Application No. H14/0357/03/A1
Date Registered 22 JUL 2003
Case Officer PJU

PROPOSED EXTENSION AND WORKS
TO HOUSE AND ADJ. BARN.

Amendment: Increase width of rear extension & replace utility window with back door.

TOWN AND COUNTRY PLANNING ACT 1990 NOTICE OF ACCEPTANCE OF AMENDMENT

location : SOUTH COTTAGE COLLEGE FARM,
STARLODE DROVE,
WEST PINCHBECK.
LINCOLNSHIRE.

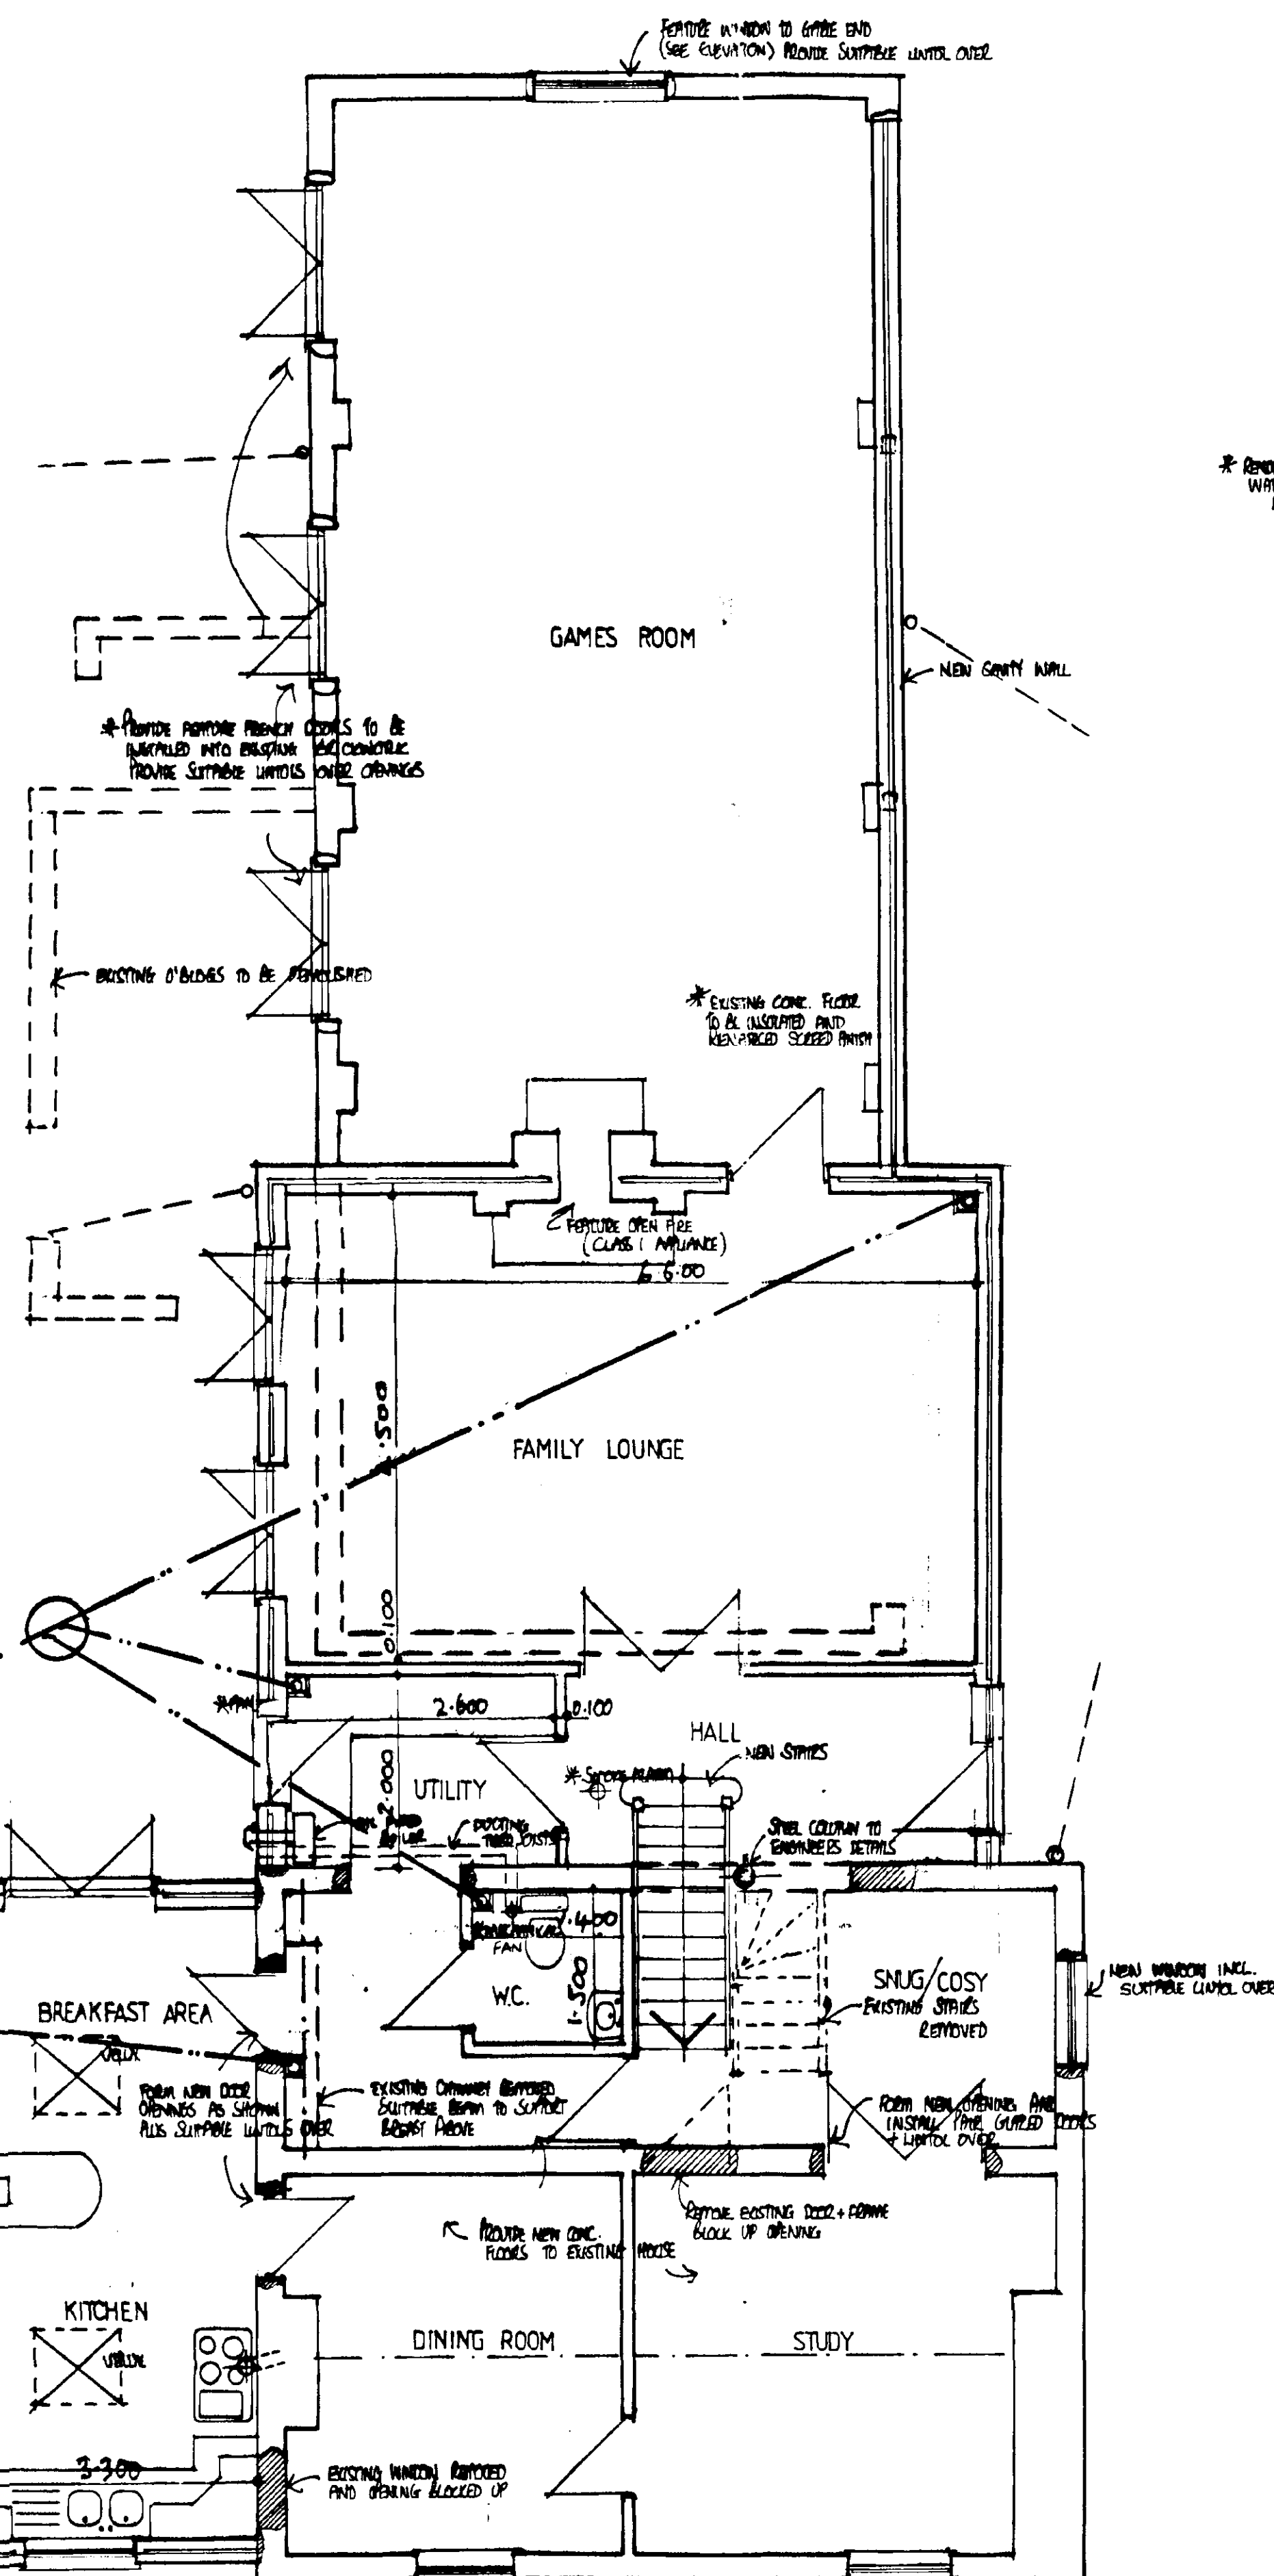
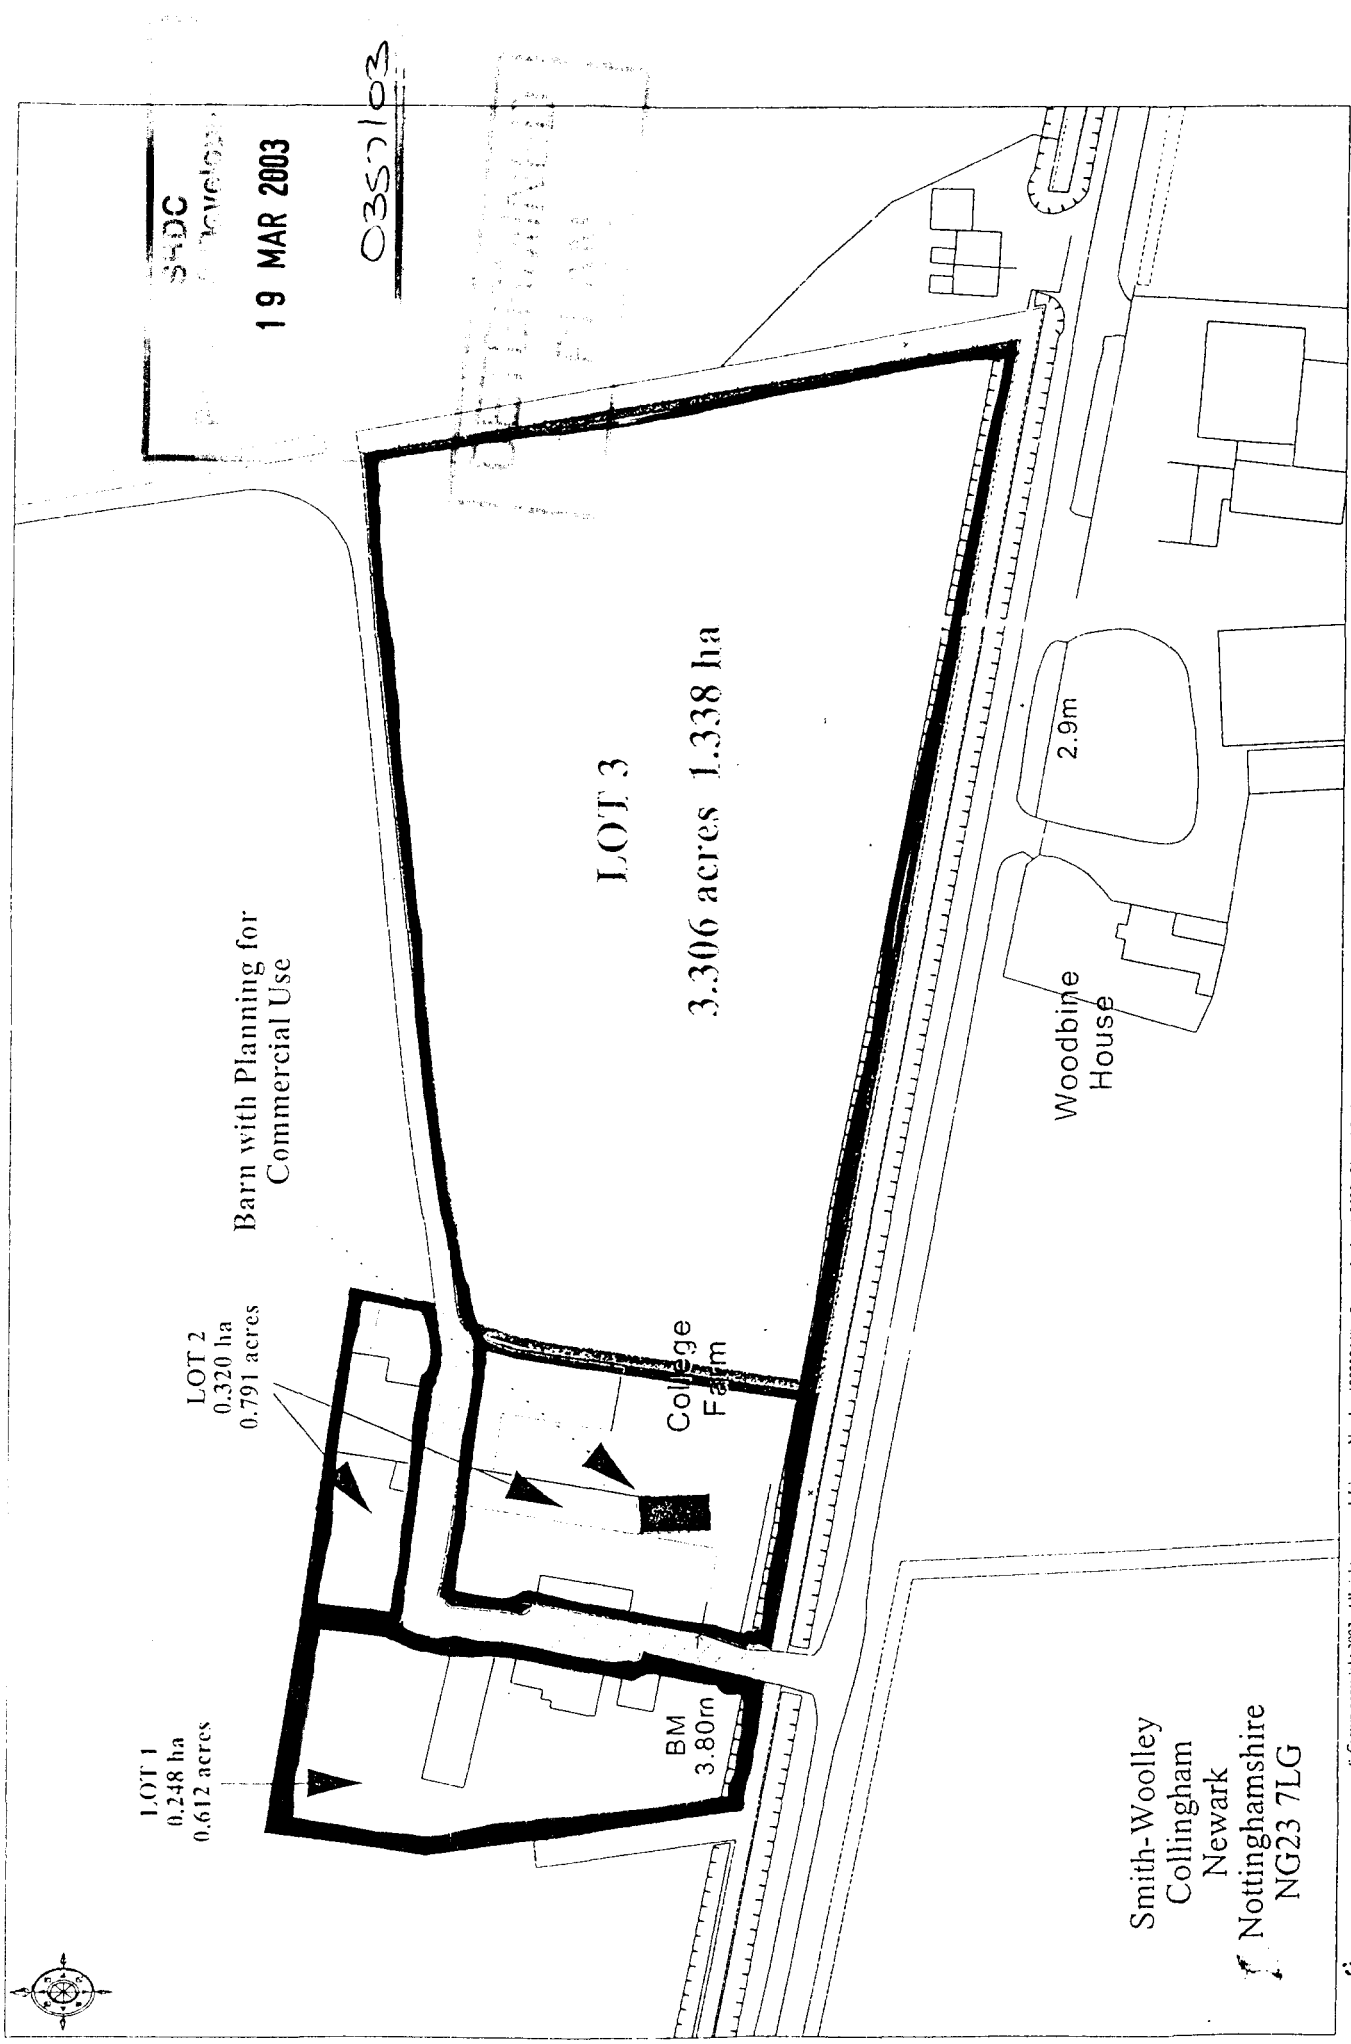
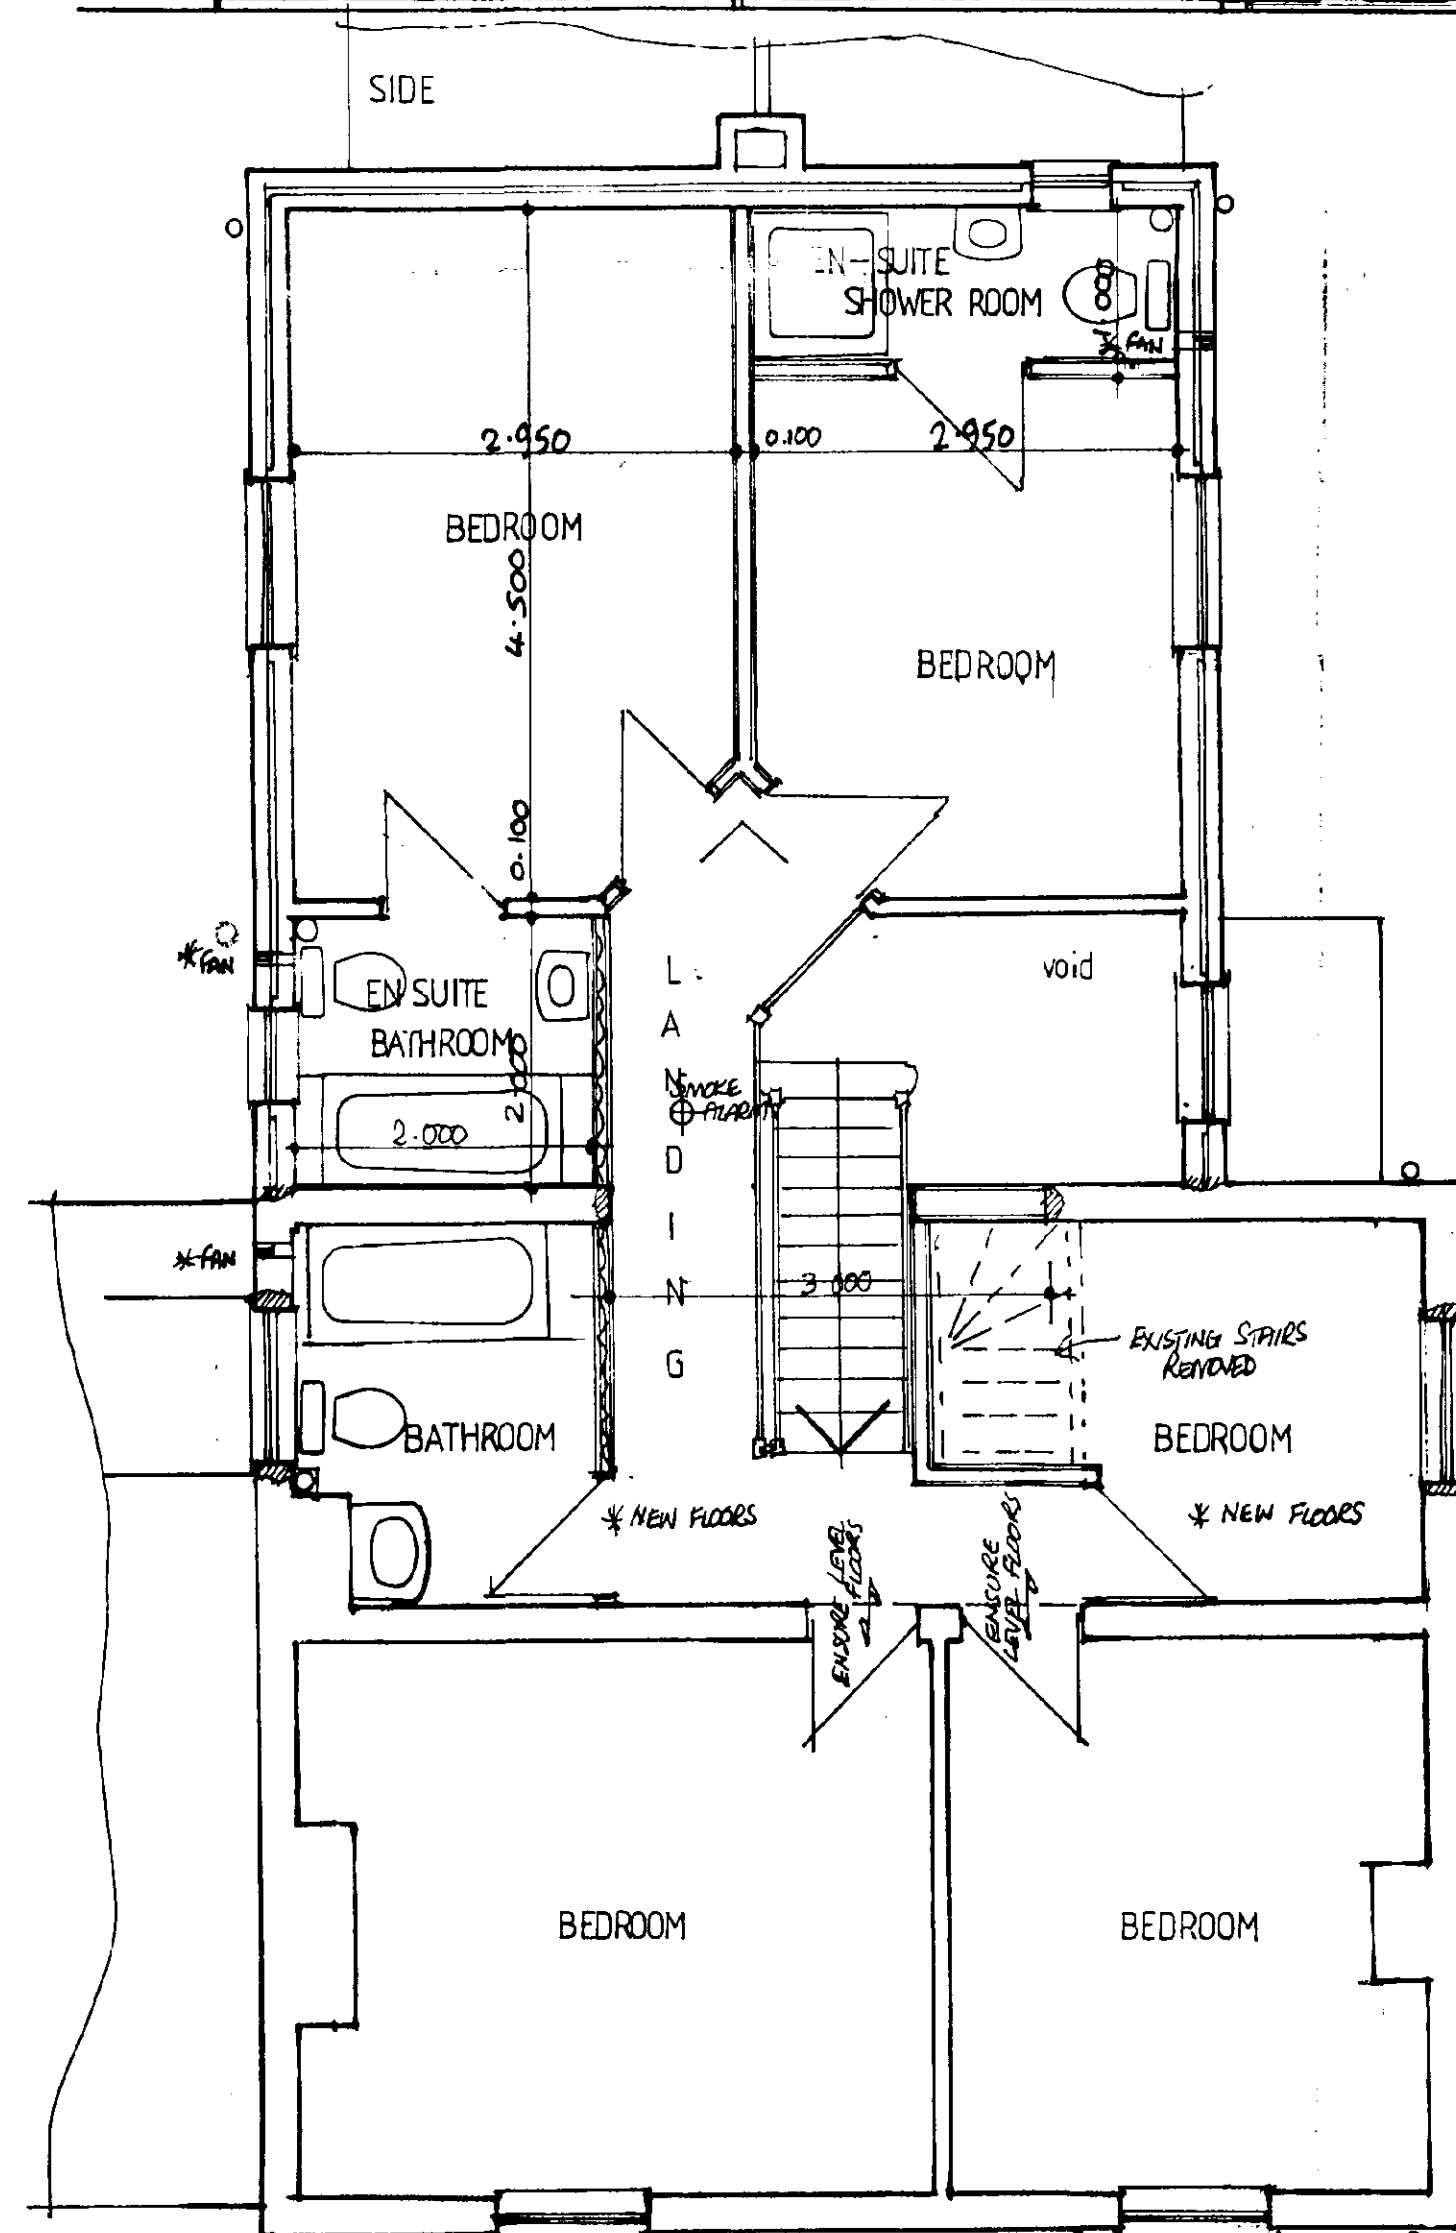
WIDTH OF REAR EXTENSION
INCREASED.
WINDOW TO UTILITY REPLACED
WITH BACK DOOR.
